**Subject:** R-6 Small Infill Design Review – 107 Monument Street

**Date of Review:** Thursday, July 23, 2015

On Thursday, July 23<sup>rd</sup>, a design review according to the *City of Portland Design Manual* Standards was performed for the proposed new construction of a single-family dwelling at 107 Monument Street. The review was performed by Caitlin Cameron, Urban Designer, Planning Division of the Department of Planning & Urban Development. The project was reviewed against the *R-6 Small Infill Development Design Principles & Standards* (Appendix 7 of the Design Manual).

A2.1

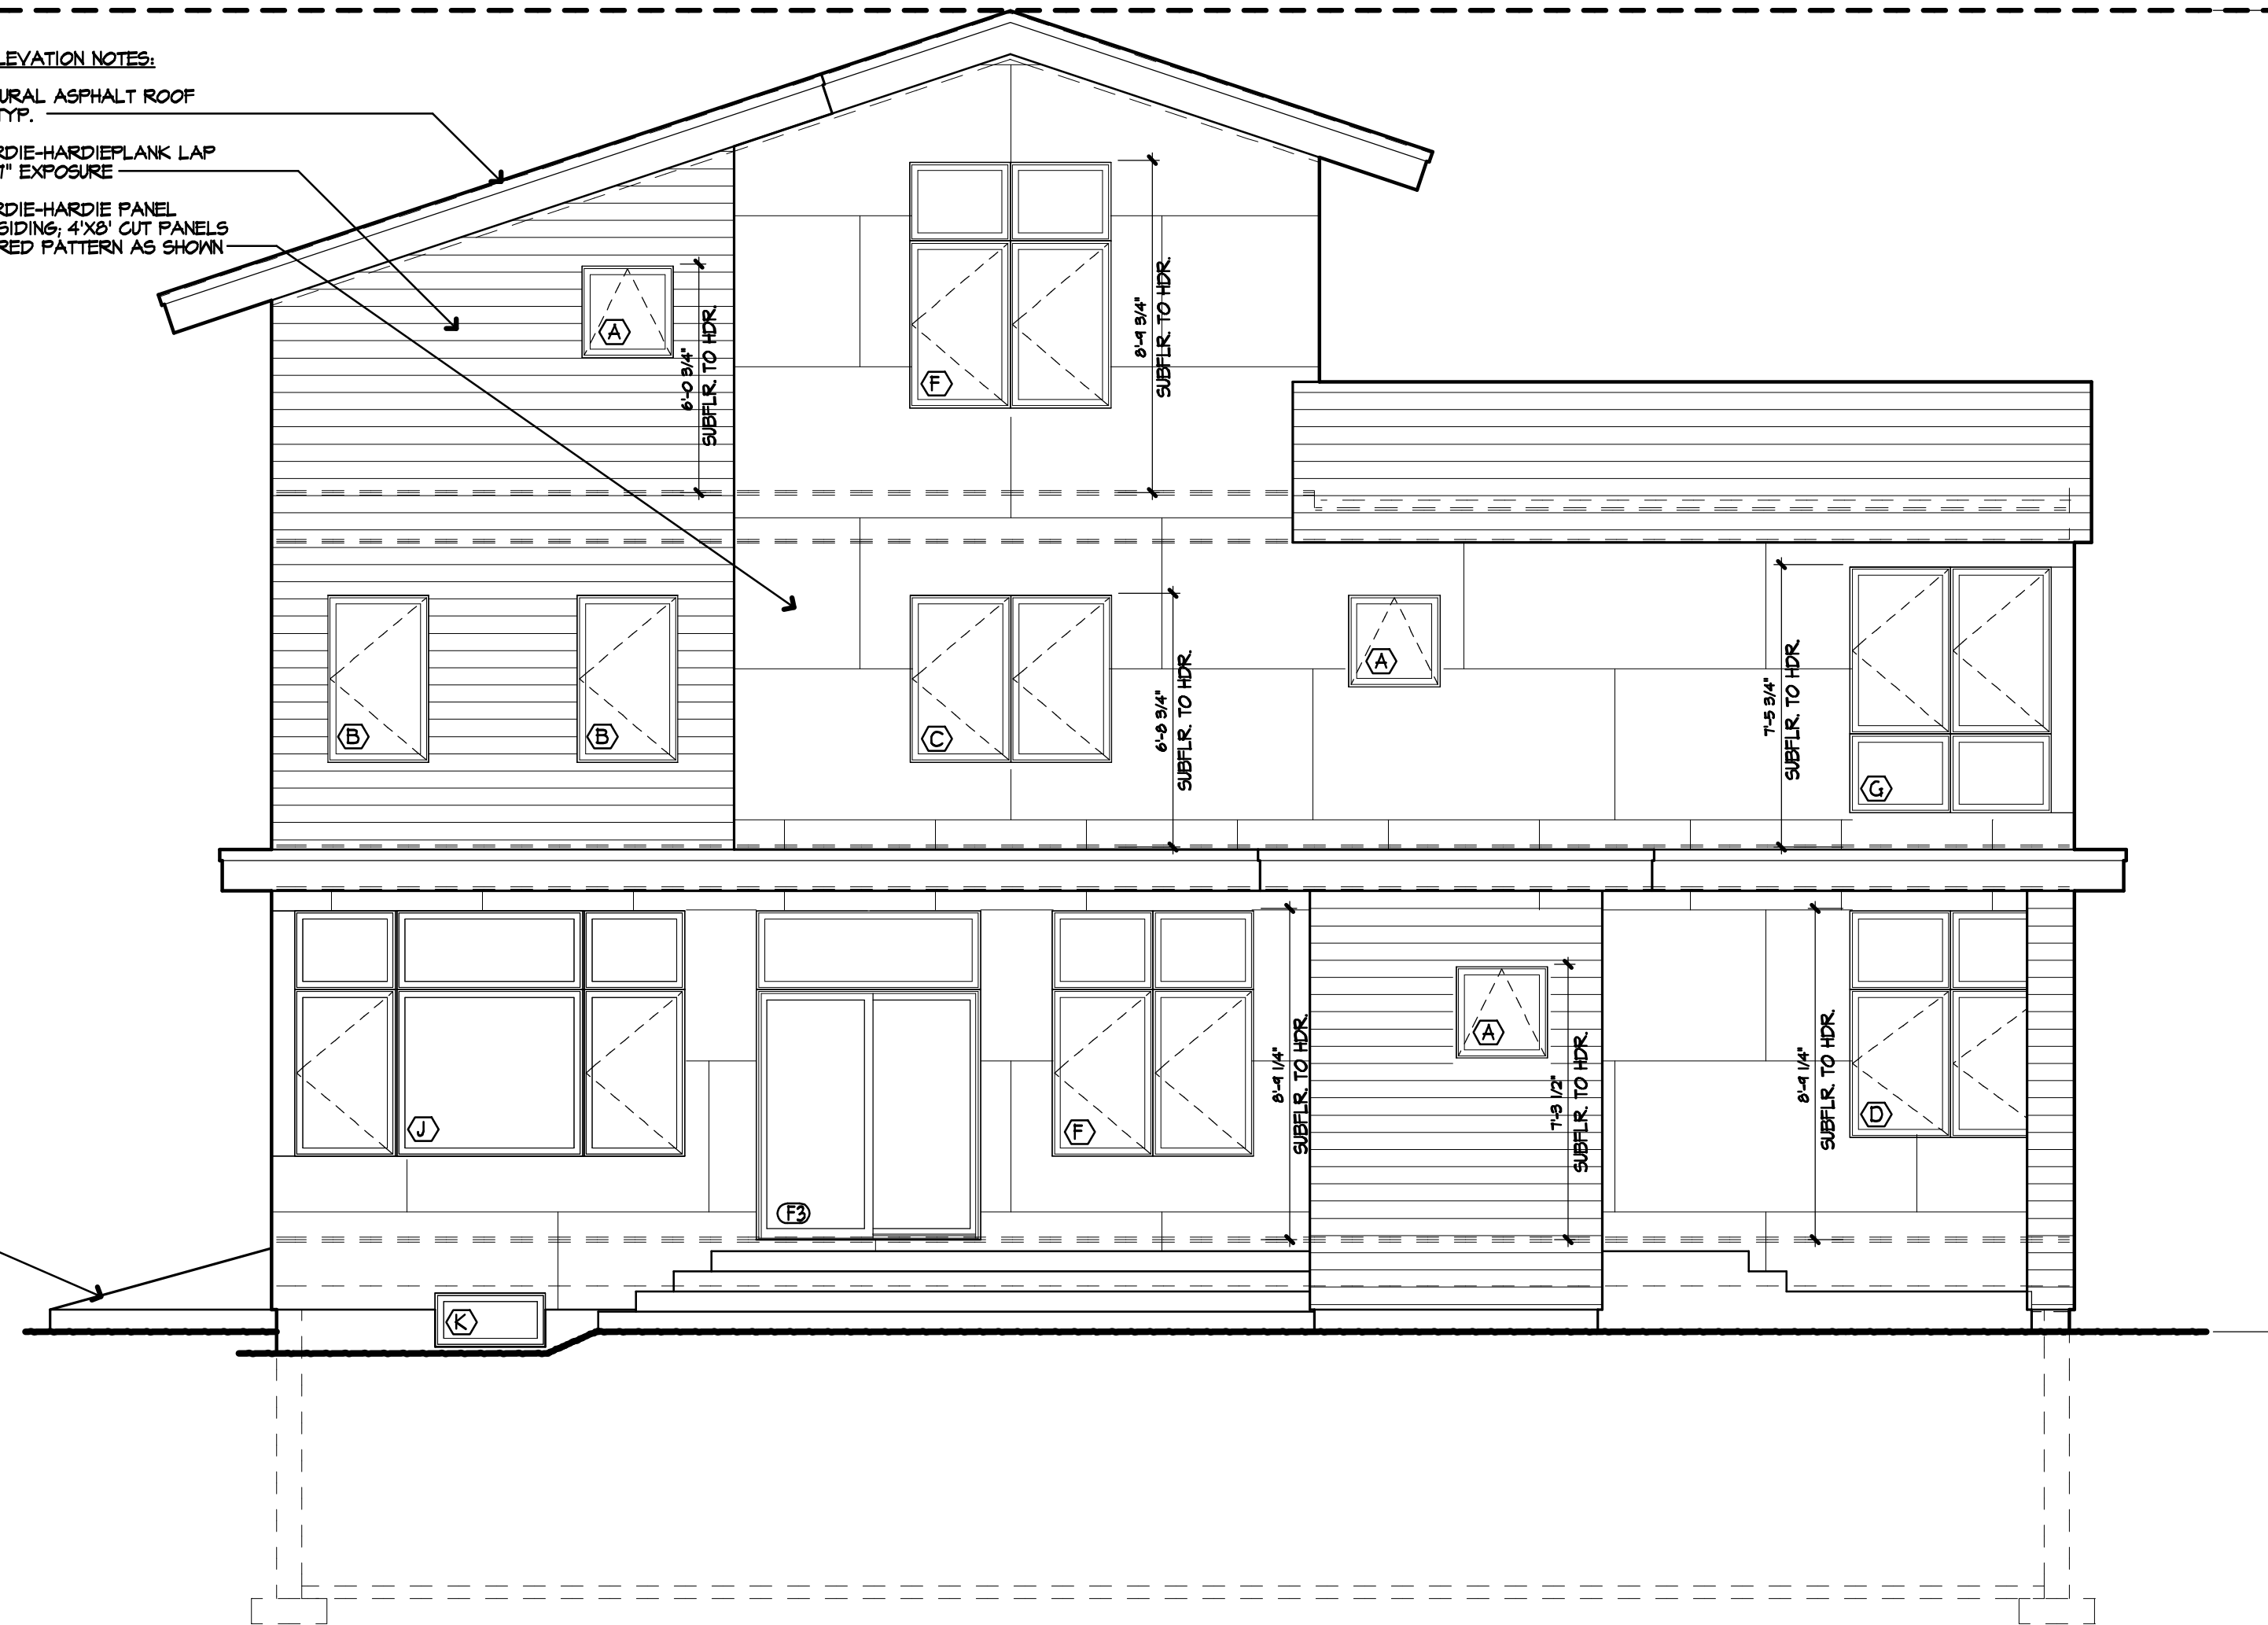
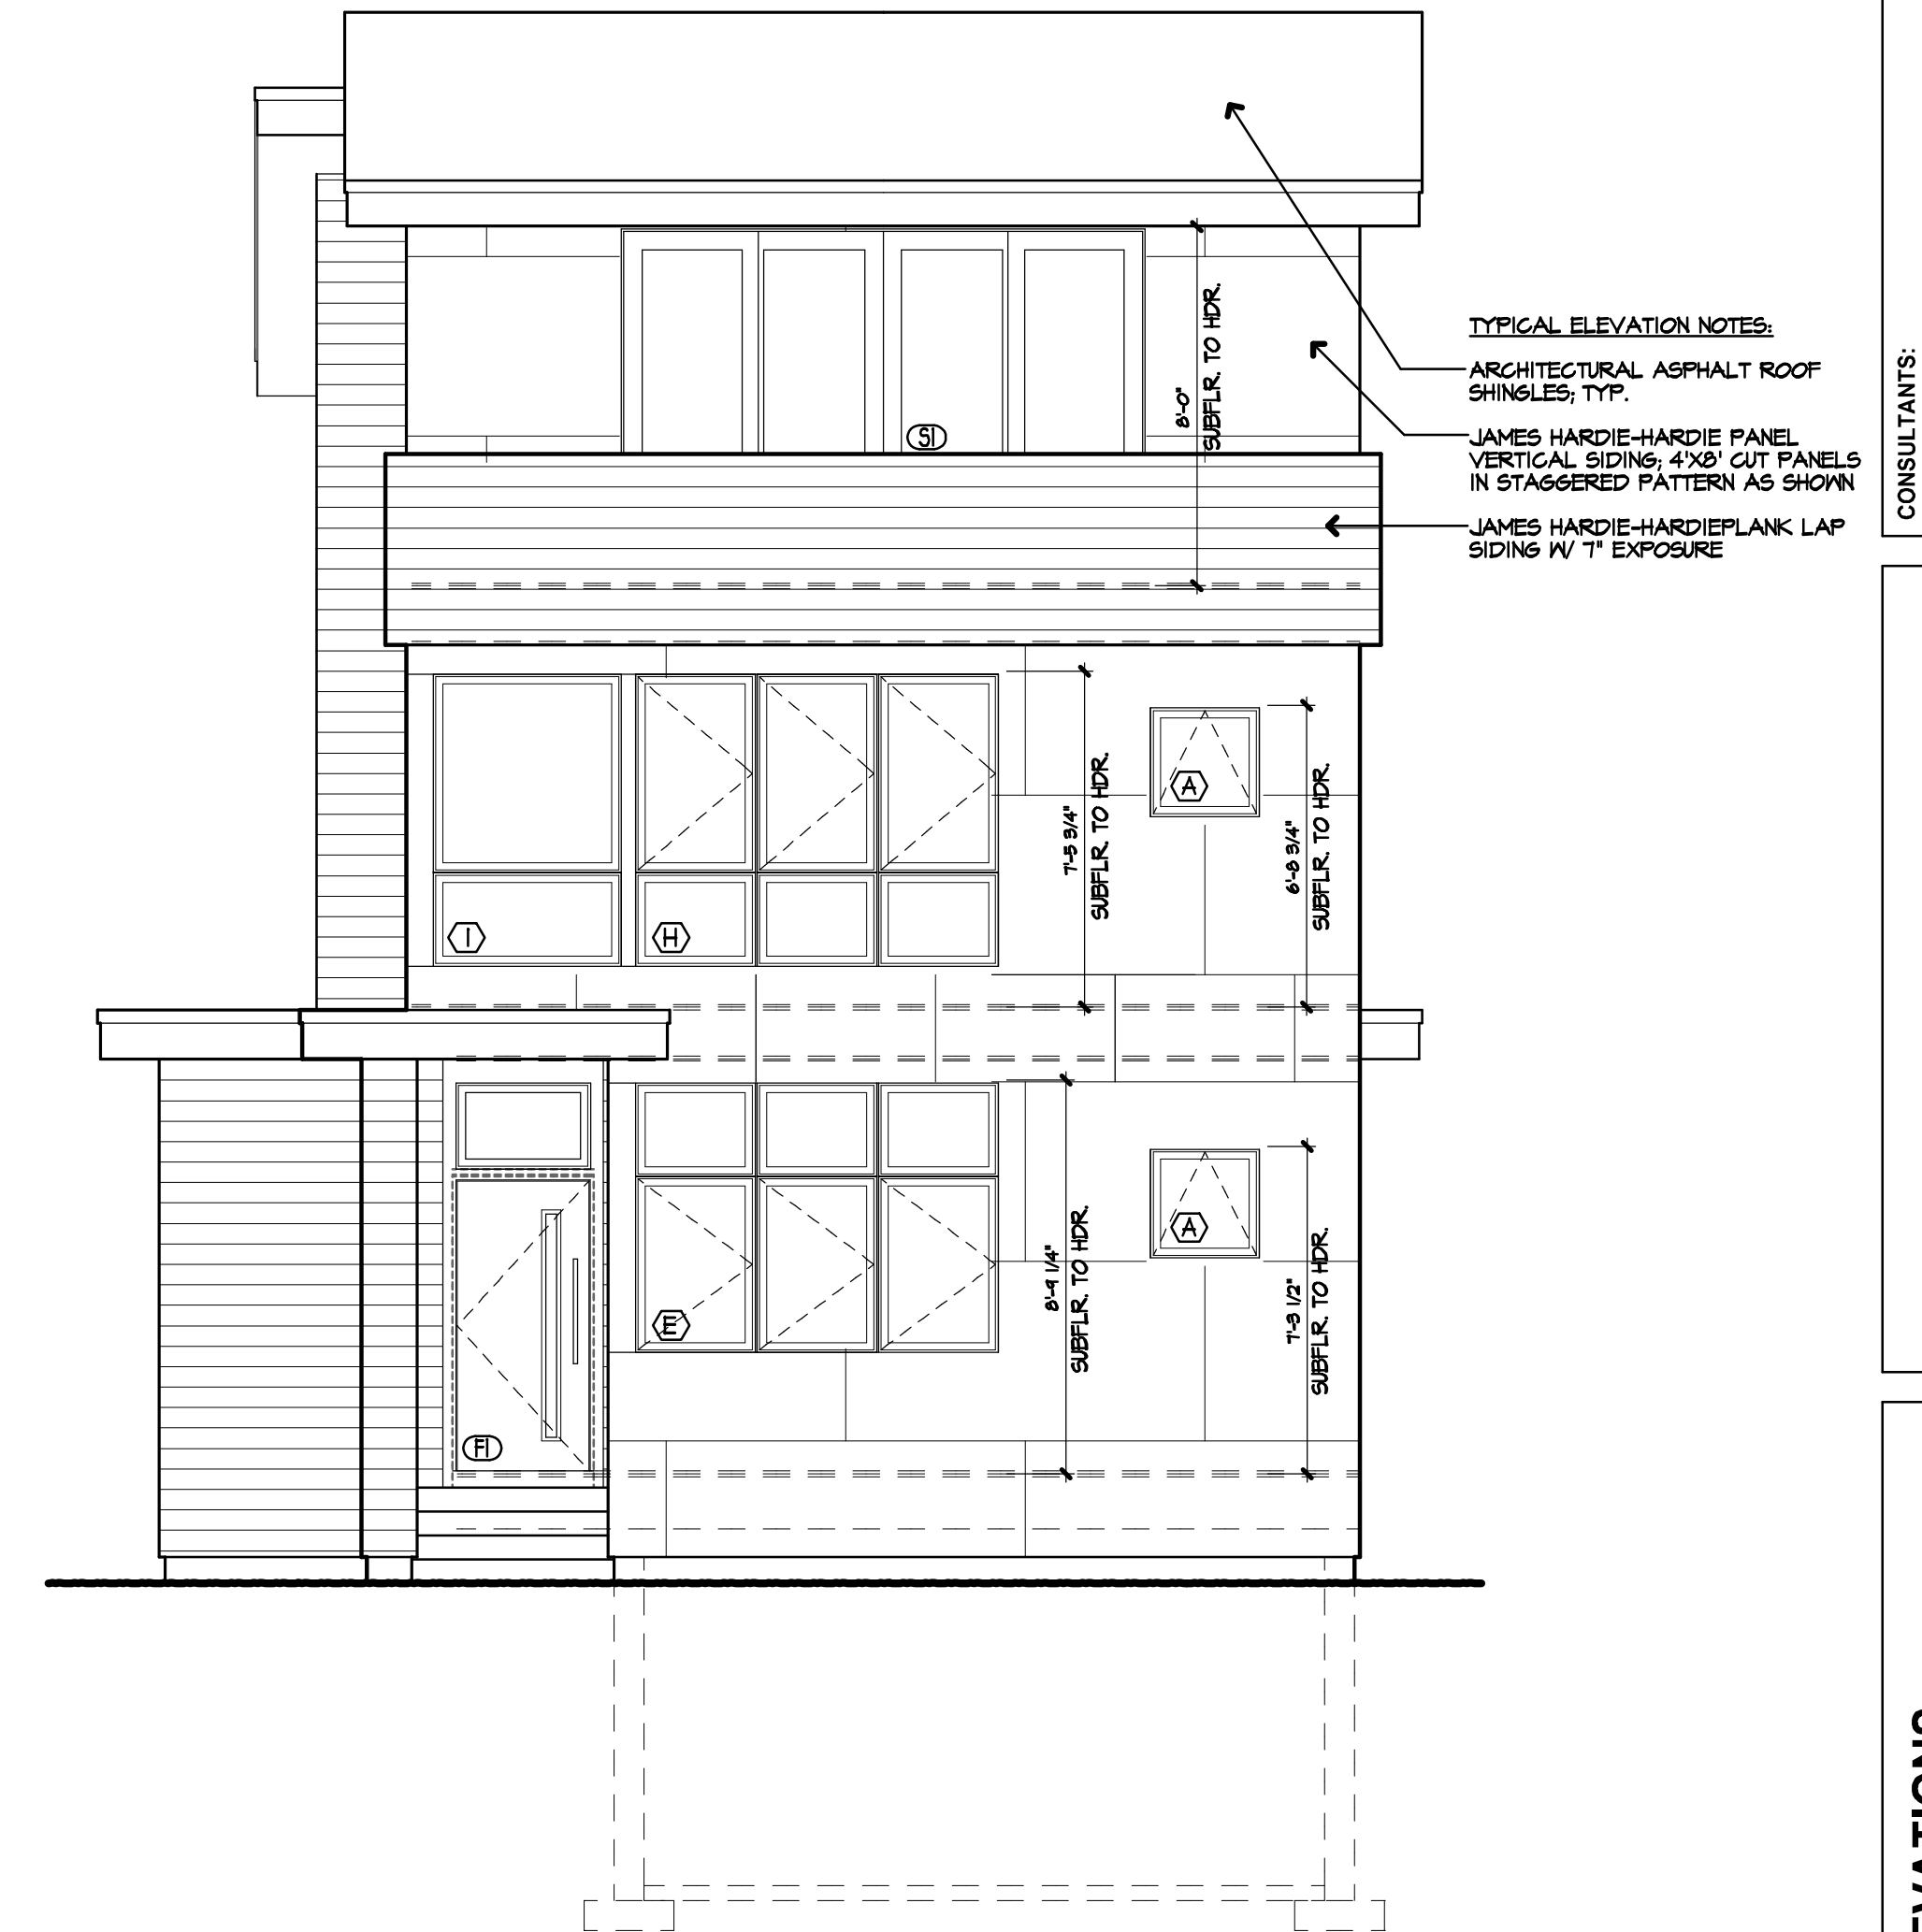
*Principle G Materials – Not Met – The use of large composite panels is not found in the residential neighborhood context and determined not appropriate for a single-family building.*

- *G-1 Materials:* The clapboards are in keeping with the residential context. Panels are not a building material found in the neighborhood and lack the scale, texture, and visual interest of a smaller-scale material choice. Predominant and contextual materials choices include clapboard (which may differ in scale), shingle, vertical siding (tongue-in-groove, board and batten).

- *G-2 Material and Façade Design:* The materials are appropriately placed according to their nature. The exception is the use of clapboard on the parapet/balcony edge at the front of the house. A lighter material, such as a rail should be considered. The use of shingles, a solid wall, and a rectilinear line creates a heavy form at the roof lines of the two-story mass.
